November 30, 2018

**Re: Status of Improvement Permit Application– SFD1811-0004**

Andrew Currin, R.E.H.S  
Environmental Health Specialist  
Harnett County Department of Public Health

Revised  
Side plan  
12-21-18

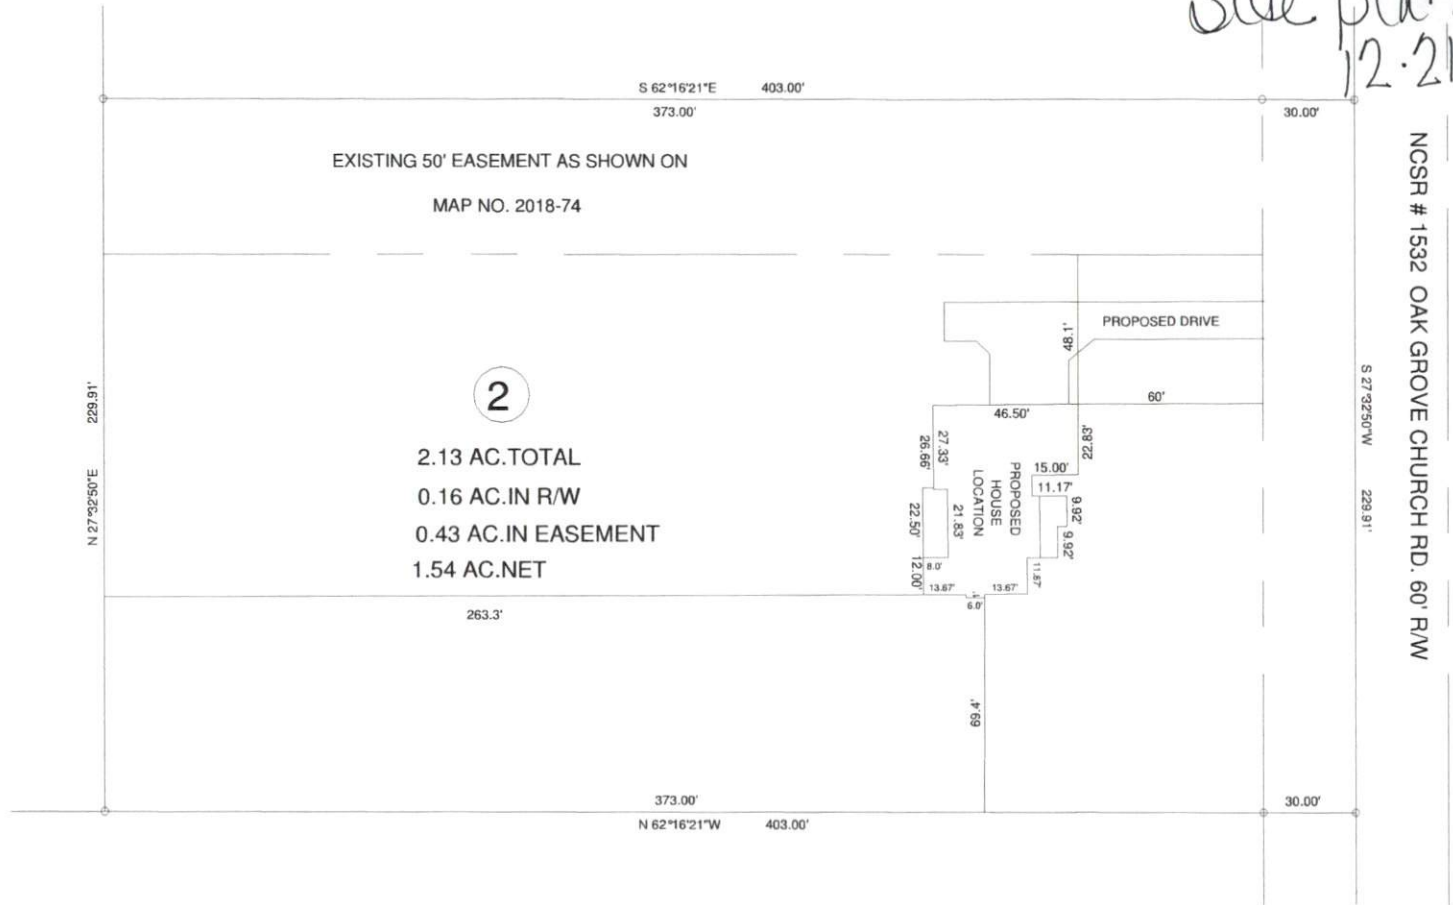
- 1. Use pink flags to mark property lines and irons that are set by surveyor need to be visible.
- 2. Use orange flags to mark house corners (*\$25.00 fee incurred*)
- 3. Directions not clear to property (*\$25.00 fee incurred*)
- 4. Property needs all brush or vegetation removed
- 5. Driveway not shown on site plan
- 6. Backhoe pits required in proposed septic area to evaluate due to large rocks. Call EH with pit location/specification questions.
- 7. Other- SFD shall be shifted forward (approx. 10ft) to accommodate flagged conventional system. Revise paperwork with Central Permitting.
